From: Amanda Scholes on behalf of Planning.Responses
Sent: 30 June 2020 10:09
To: Planning Scanning
Subject: FW: BN/5/20/PL, Sunnyside Cottages - SW Drainage

Please ensure that the Surface Water Drainage for the application is constructed in accordance with the plans contained within the following document:

Flint Barn_Drainage_Supplementary Report_FINAL Rev 02 (1)

PROJECT FLINT BARN BARNHAM	TITLE FLINT BARN DRAINAGE DESIGN
DESCRIPTION DRAINAGE DESIGN	
CLIENT ADDRESS Flint Barn Yapton Road Barnham Bognor Regis PO22 0AZ	DRAWING CLASSIFICATION PRELIMINARY ISSUE
DRAWING NUMBER FLB0101	REV. P03

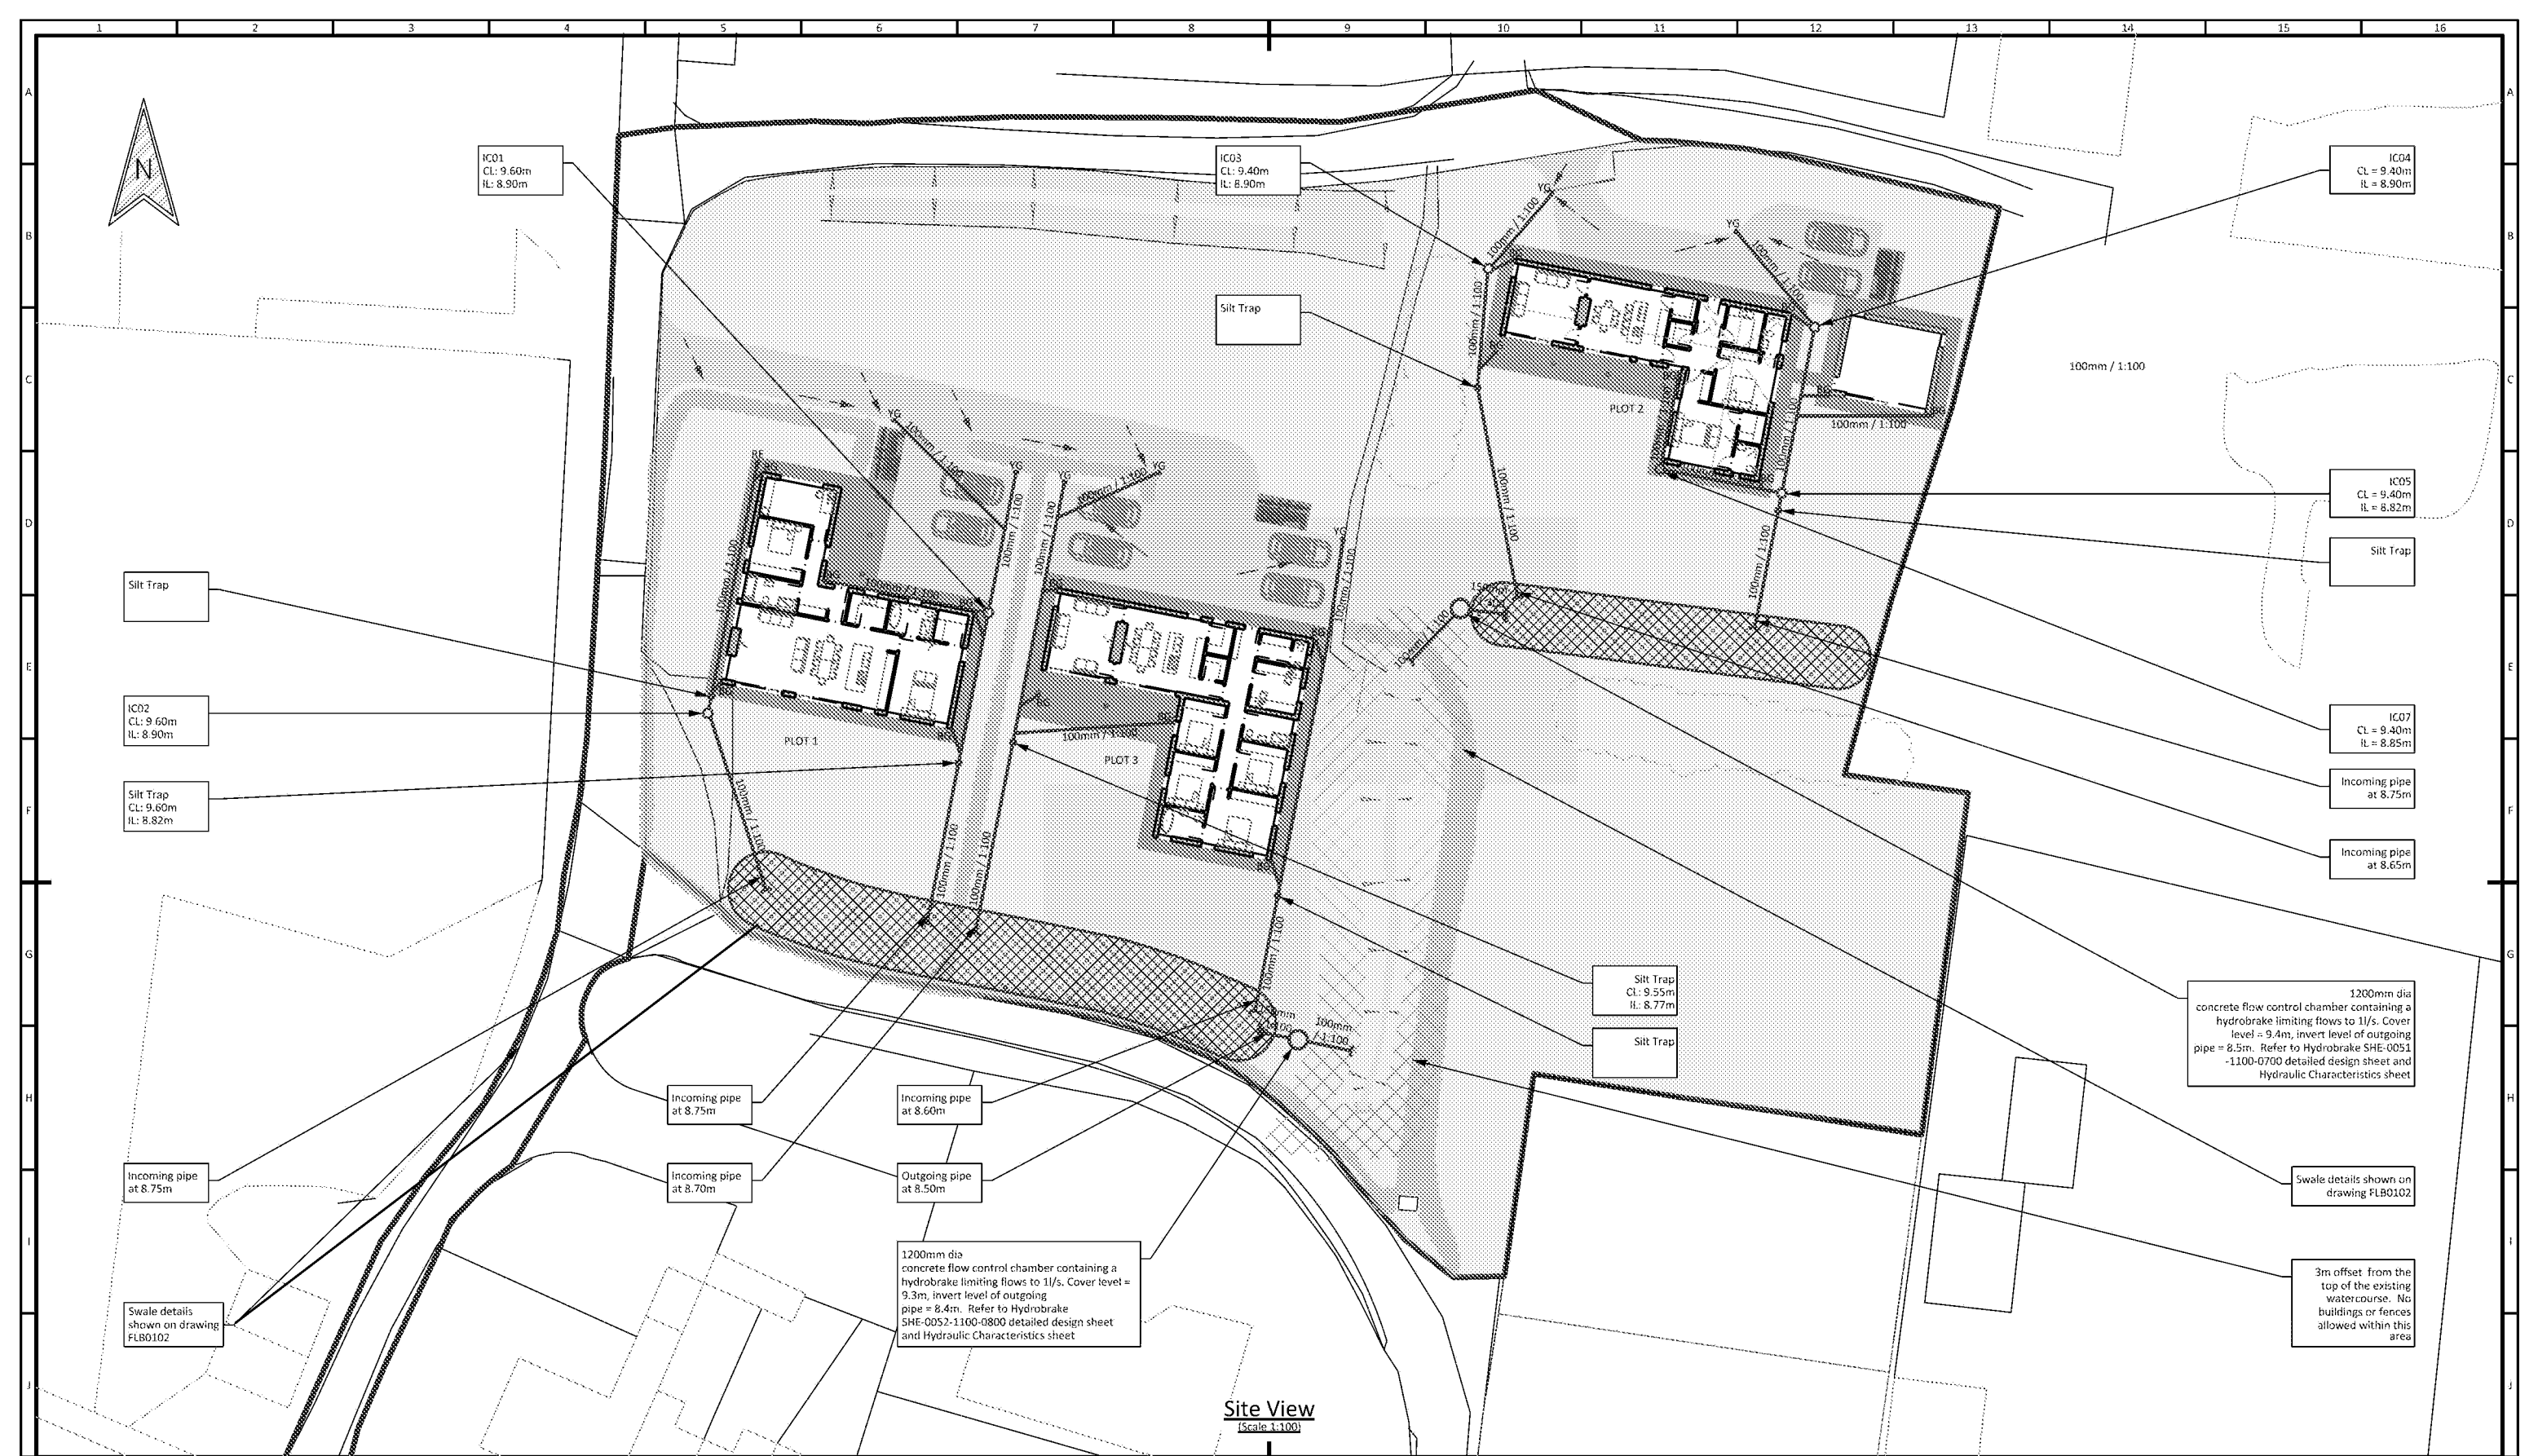
3. *Three different pipe diameters are listed in the notes on the layout, please specify on each pipe it's diameter, or, only if exceptions to a rule ie all pipe diameters 100mm unless noted otherwise on layout.*
I've clarified this on the drawings

4. *Please also detail pipe gradients or falls.*
I've clarified this on the drawings
5. *Please include cranked trash screens on the outlets from the swales to the hydrobrakes.*
I've included details for a trash screen product to be added to the outlets

6. *Please incorporate silt traps on the last connection before each inlet to the swale.*
I've added these on the drawings
7. *Please remove the bend on the eastern side of Plot 2 so that the change of direction is facilitated through the silt trap connection (see point 5).*
I've amended the drawings to suit

Hydro-Brake Optimum®

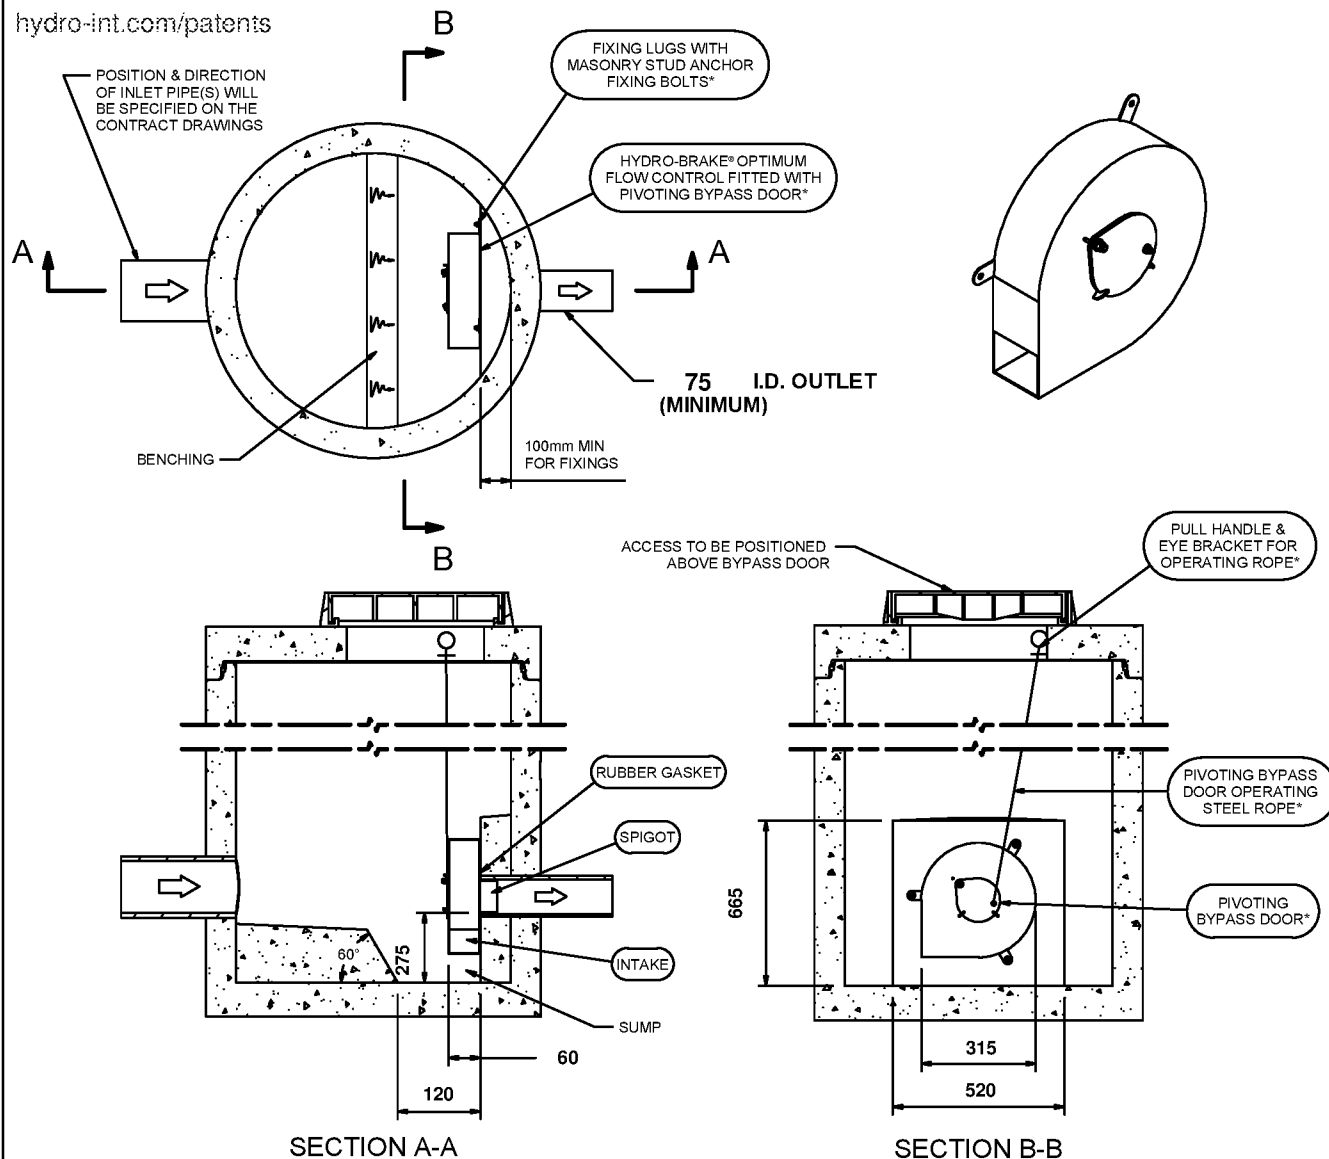
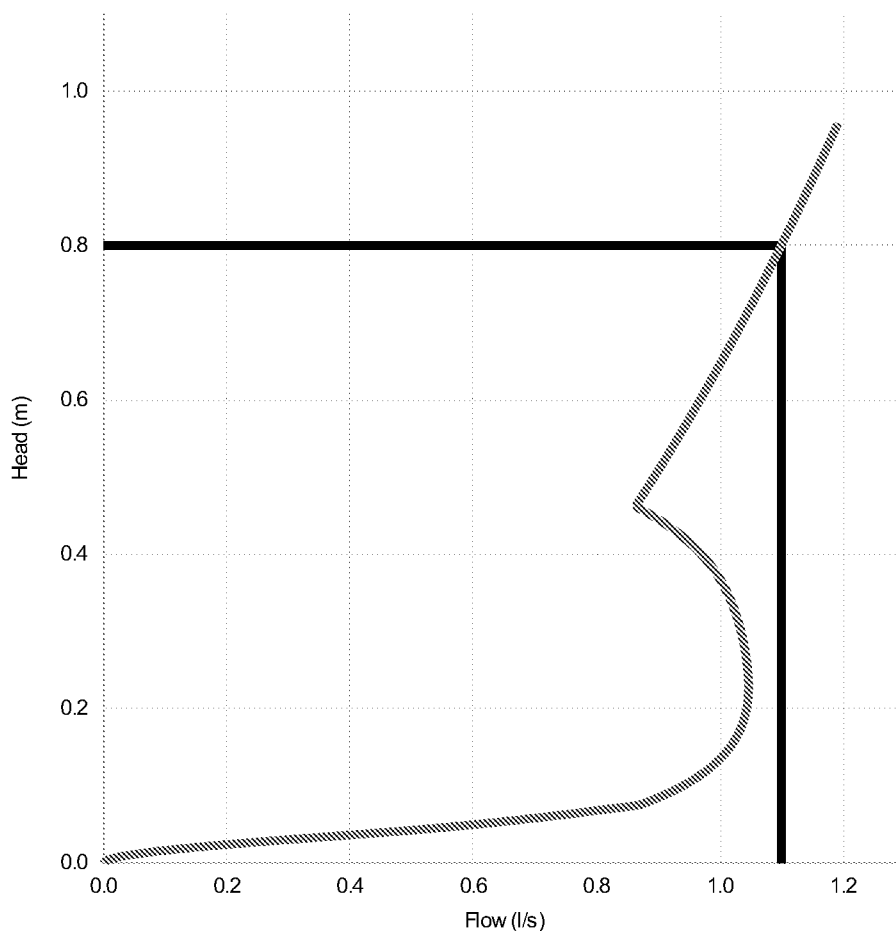
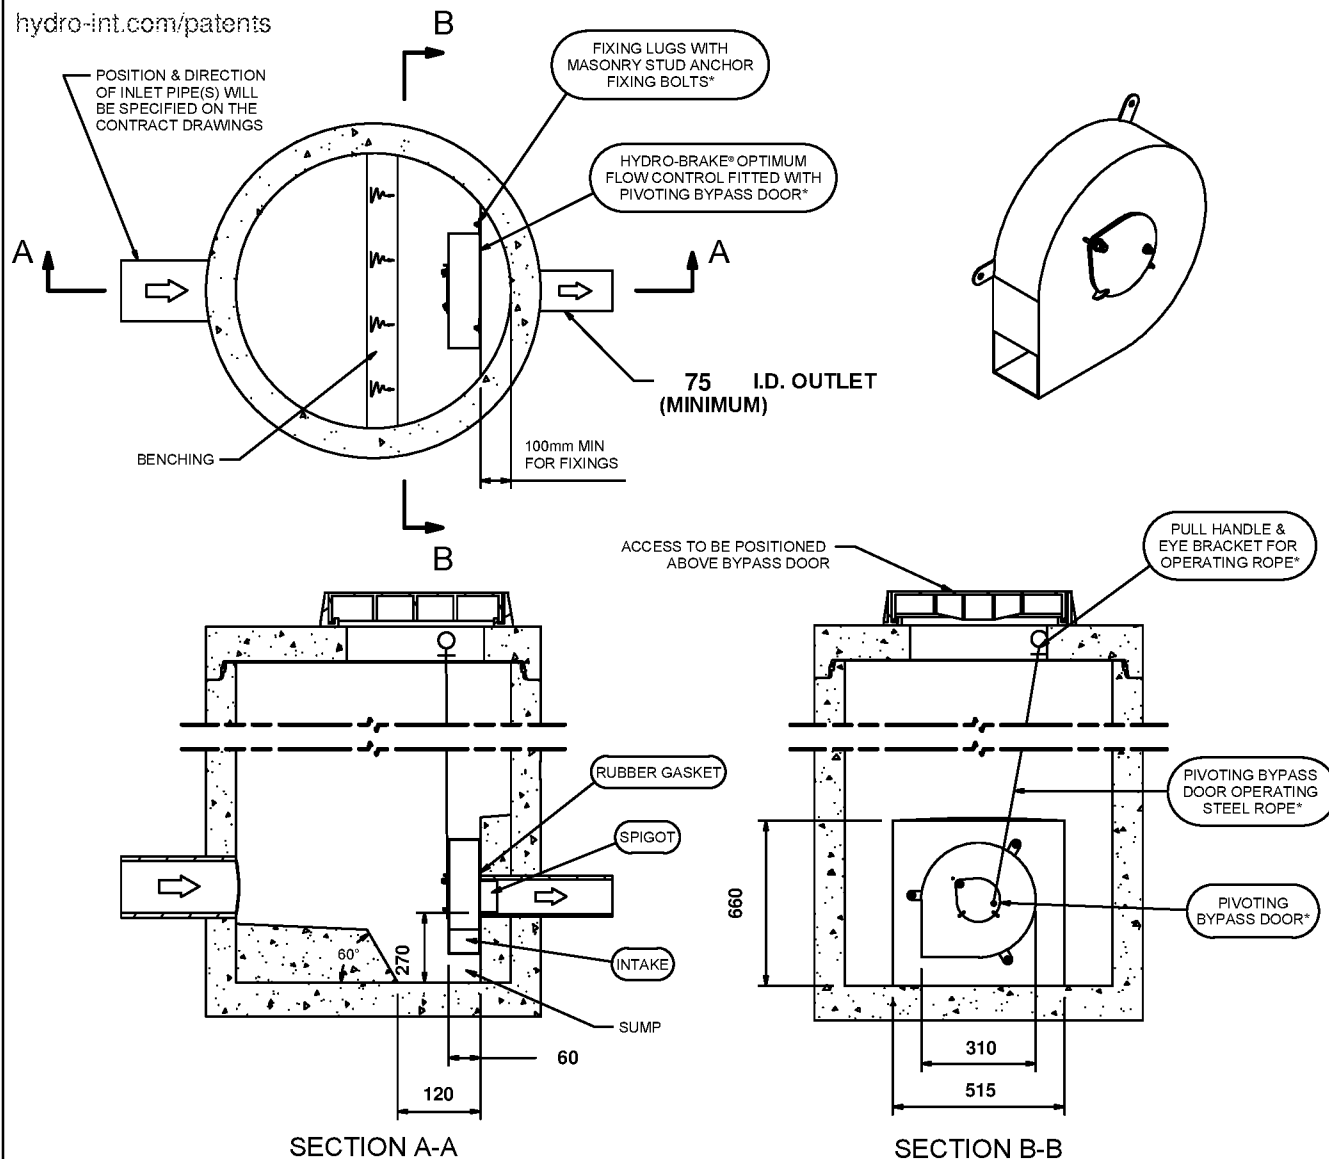
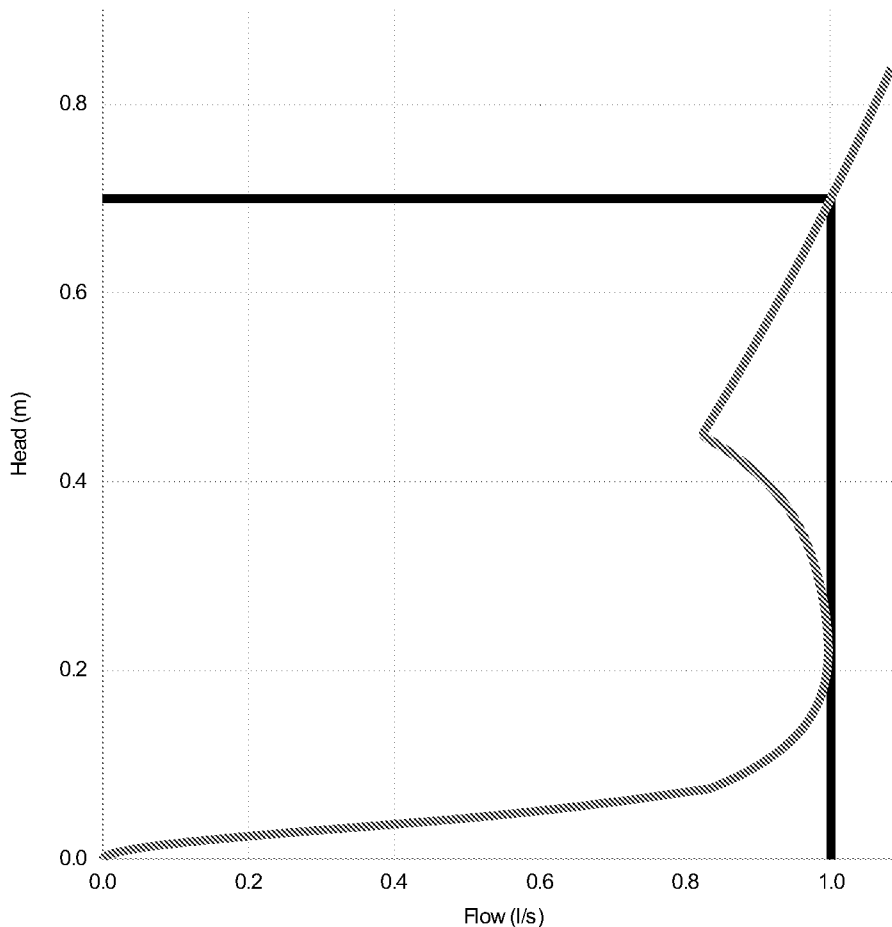
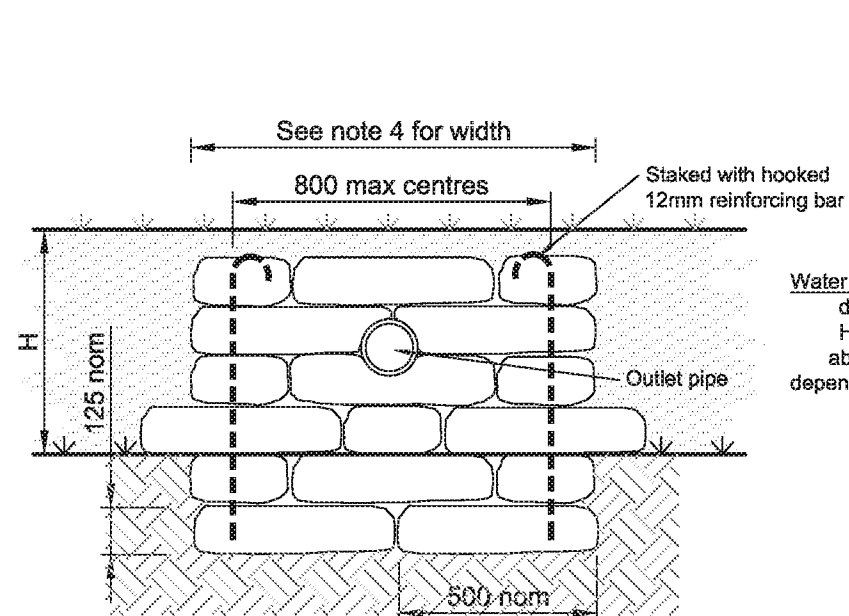
8. *Please show headwalls on the layout.*
I've added these on the drawings
9. *Please fully detail the Hydrobrake construction drawing so that it is site specific.*
I've added a standard detail for a flow control manhole in the drawings
